Development Facilitation Team (DFT) – Review Comments

Project No: PR-2020-004171 **Date:** 04/10/2024 **Agenda Item:** #6 **Zone Atlas Page:** R1-D
Legal Description: TRACT N-7-A-1, BULK LAND PLAT OF TANOAN PROPERTIES
Location: 12300 SAN ANTONIO DR between LOWELL DR NE and TENNYSON ST NE
Application For: Subdivide 1 Tract of land into 9 lots and 1 tract, vacate existing easements and grant new public easement.

Application For: SD-2024-00059 – Preliminary Plat

Project Name: 12300 San Antonio Dr NE

SHEET 2 OF 5

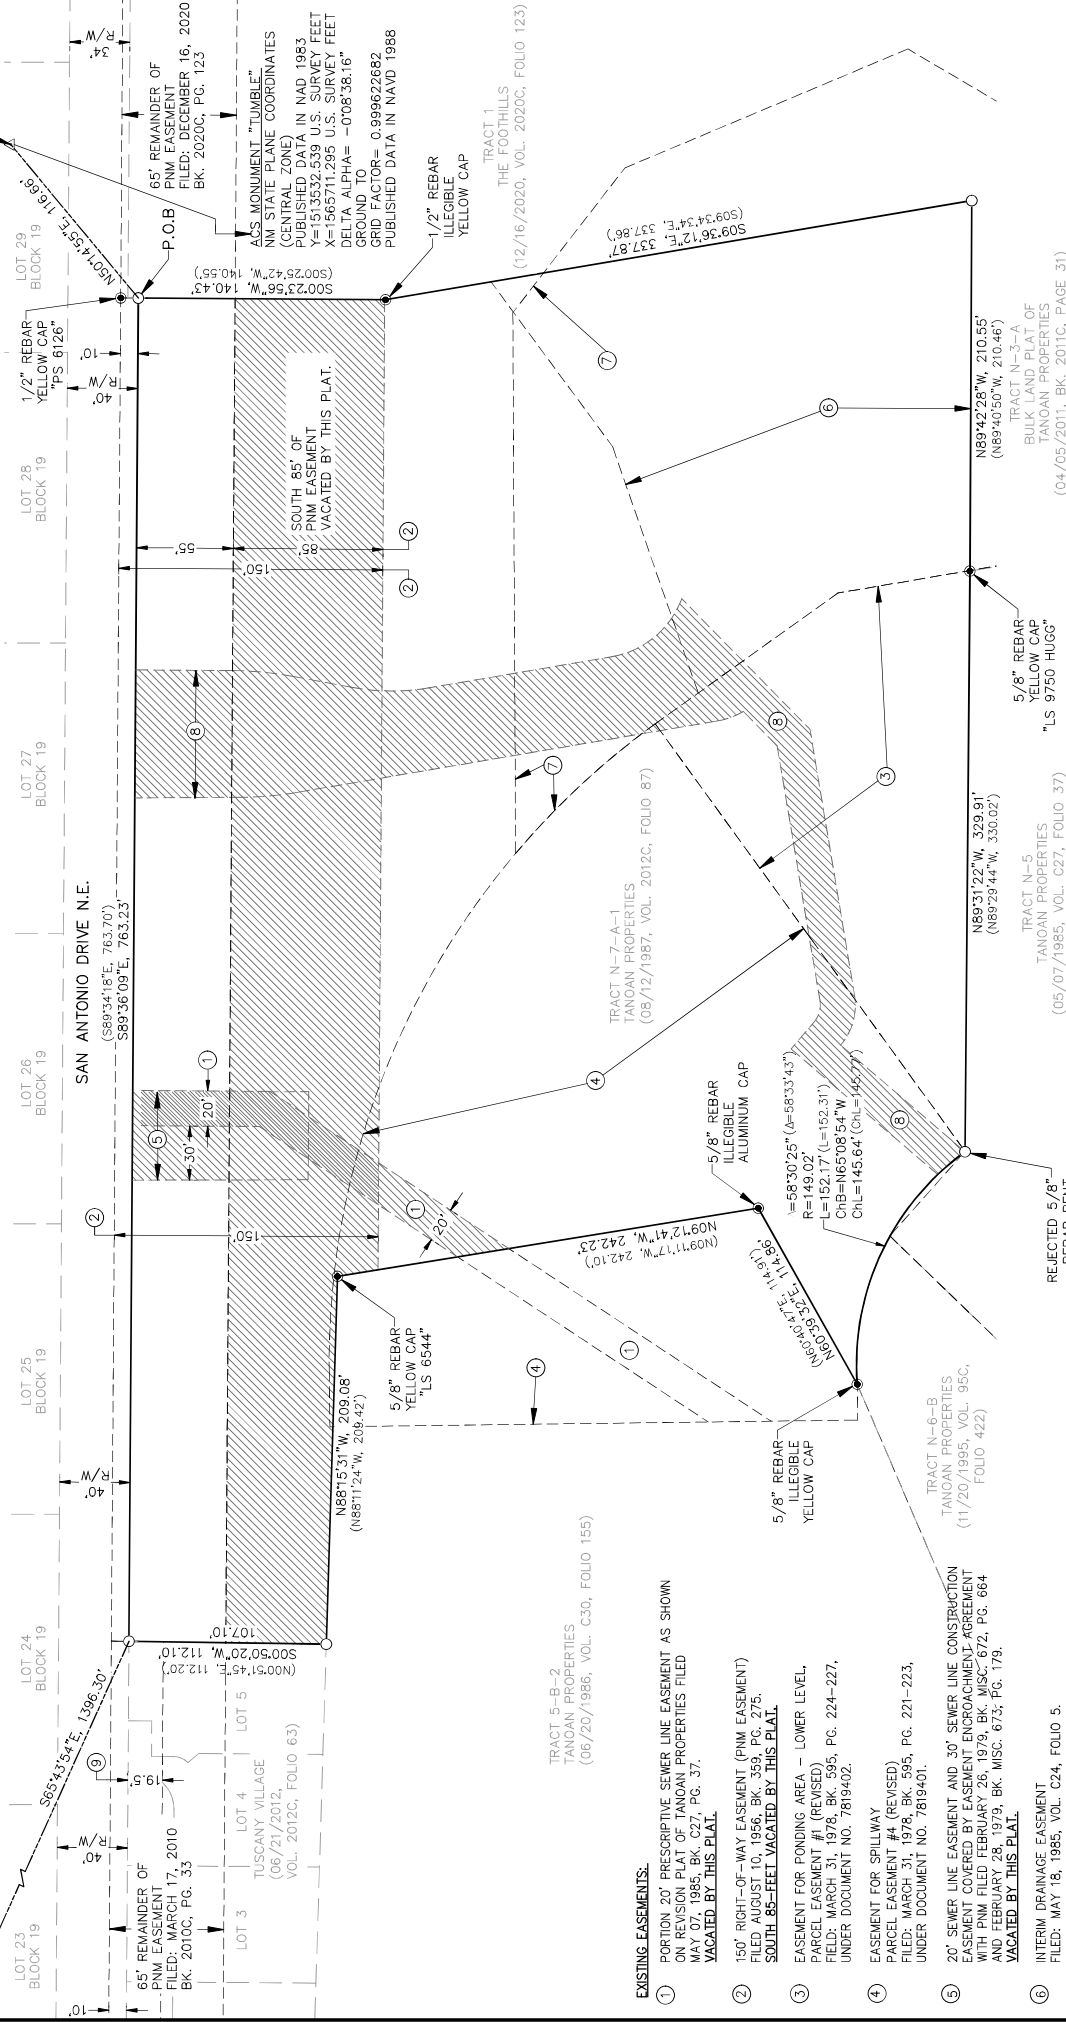
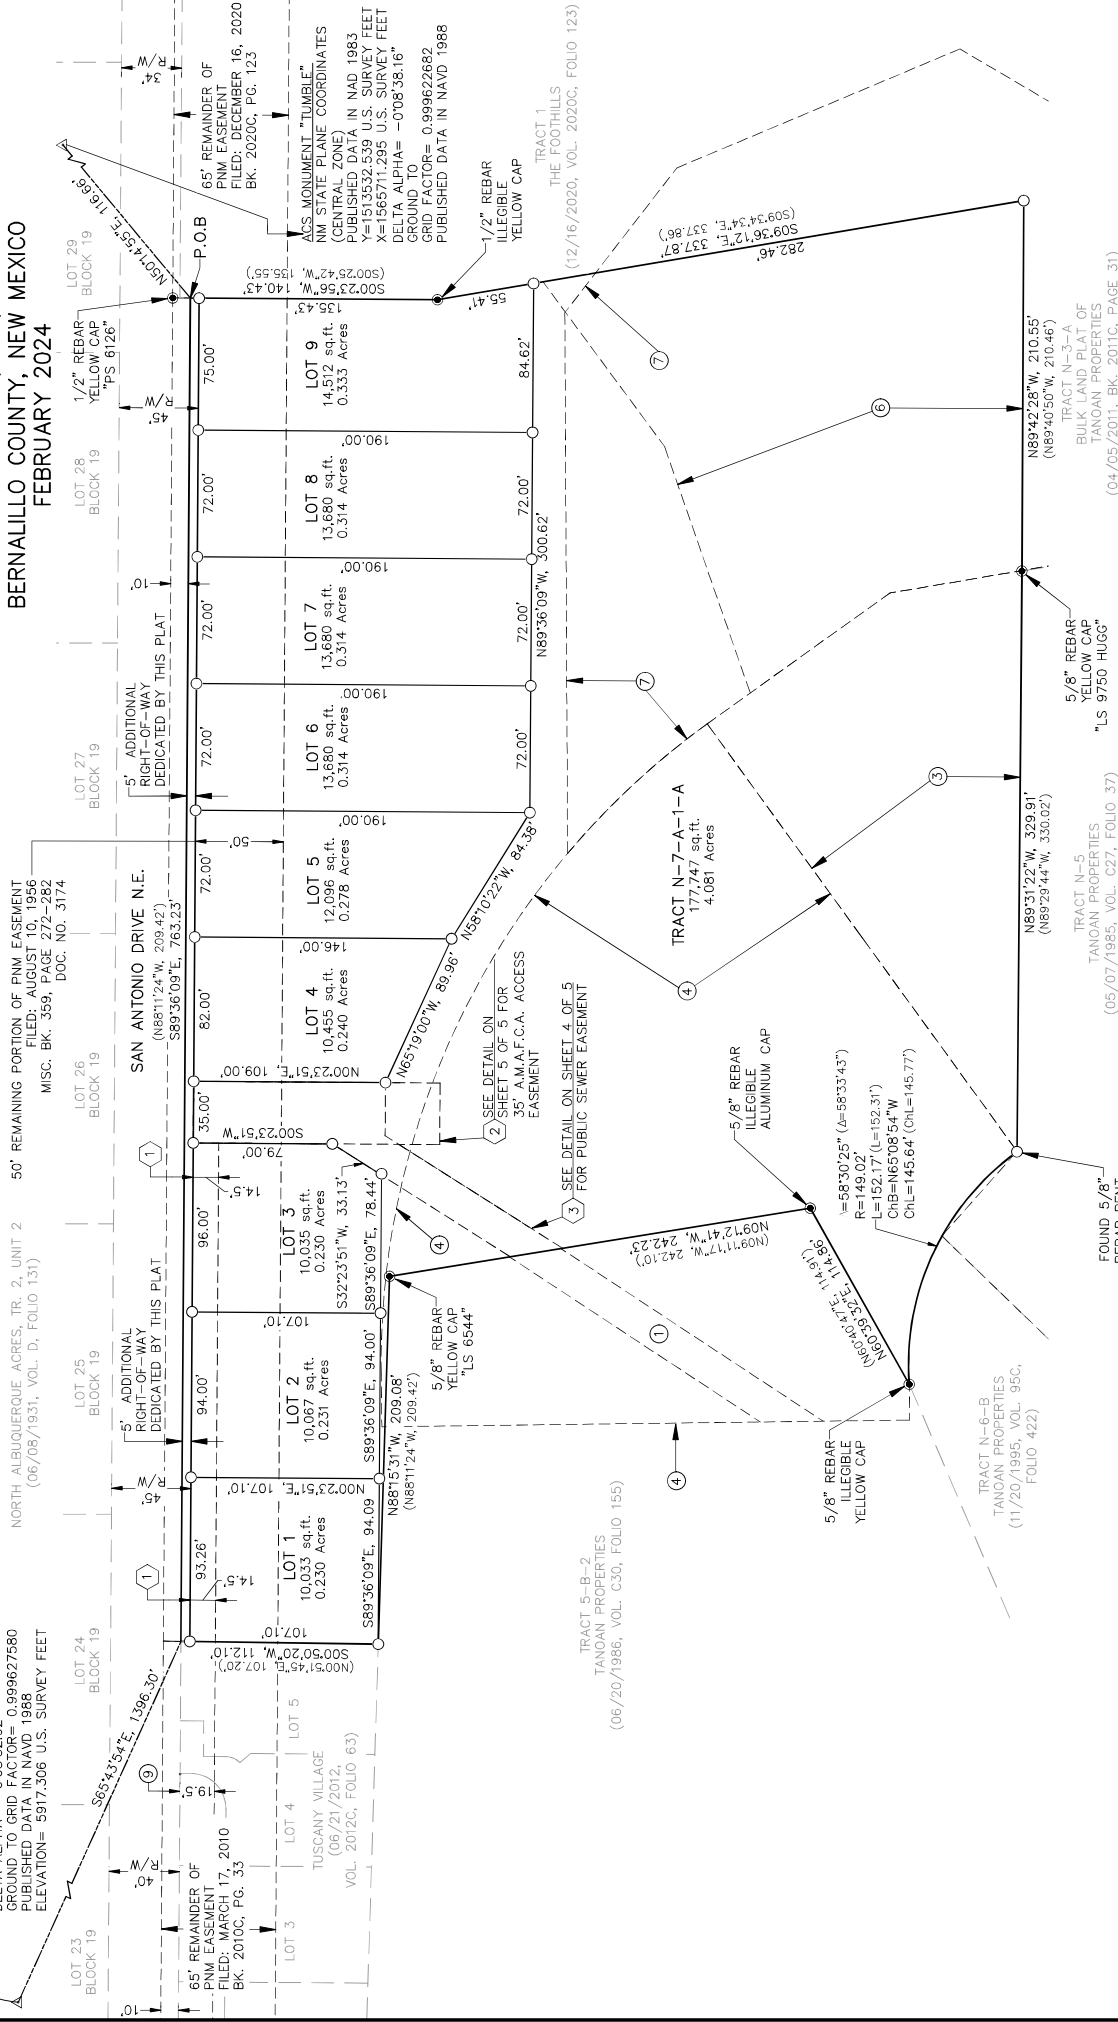
- The Application number must be corrected on the plat.
- An obsolete DRB Infrastructure List form has been used. Please use the updated DHO form for the Infrastructure List. This form can be obtained online at the following link: https://documents.cabq.gov/planning/development-hearing-officer/DHO_infrastructure-list.pdf

- Four (4) Vacations of Easement are proposed in the justification letter (for the Vacations) in the application submittal and as noted/depicted on the Plat. However, only two Vacations of Easement (a Vacation of Public Easement and a Vacation of Private Easement) were processed by staff and placed on the April 10th DHO agenda. For a decision to be made on the two remaining Vacations of Public Easement, two additional applications for Vacation of Public Easements will need to be processed and the application fees paid for prior to their hearing, with more detail on the application submittal for each Vacation in the "Brief Description of Request" section of the application form being provided to staff processing the additional applications (at PLNDRS@cabq.gov).

- For the portion of the 20-foot prescriptive sewer line easement proposed to be vacated on the subject property (Easement #1), the Applicant must contact the owner of the abutting property (DAVID PRICE ETAL ATTN: AMERICAN GOLF CORP at UPC: 102206232441910205) southwest of the subject property and confirm in writing that they do not object to or have any issues with the proposed vacation, as it appears on the Plat that the 20-foot prescriptive sewer line easement proposed to be vacated connects to or is part of the easement on their property.

DETAIL- PUBLIC SEWER EASEMENT

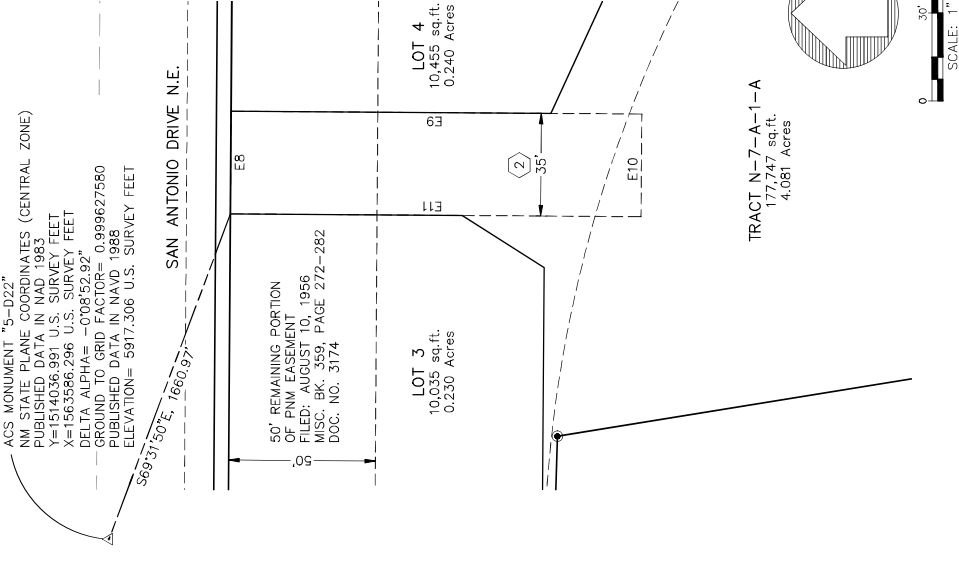
1. No objection
 - a. The sanitary sewer easement is being replaced by a new easement.
